REDTAIL RANCH FILING NO. 1

CONSTRUCTION DRAWINGS

PCD No. SF-18-021

60' R.O.W. WARD LANE GRAVEL ROAD CROSS SECTION

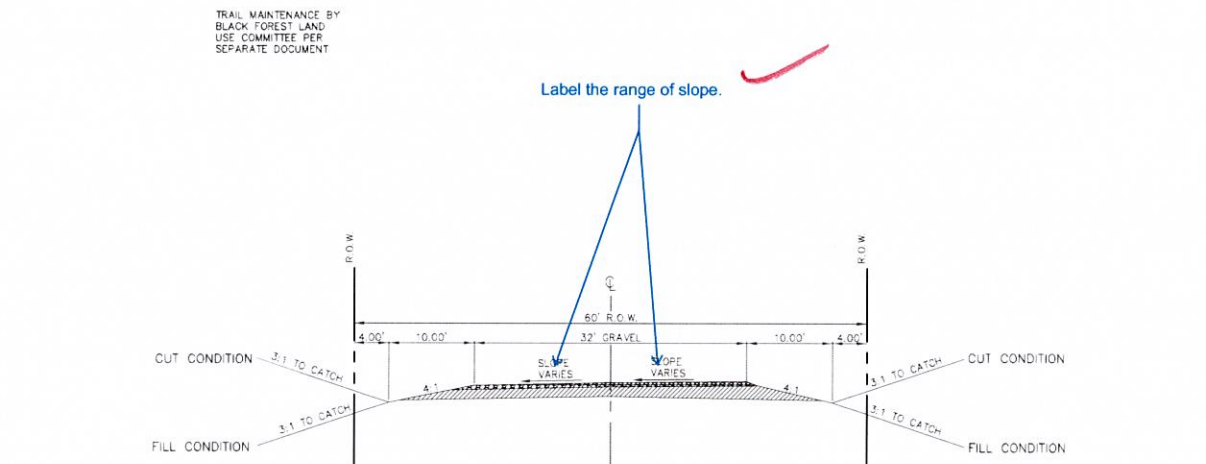
Provide stations. (~10+06 to ~xx+xx) (As shown on grading plans this cross-section is not met.)
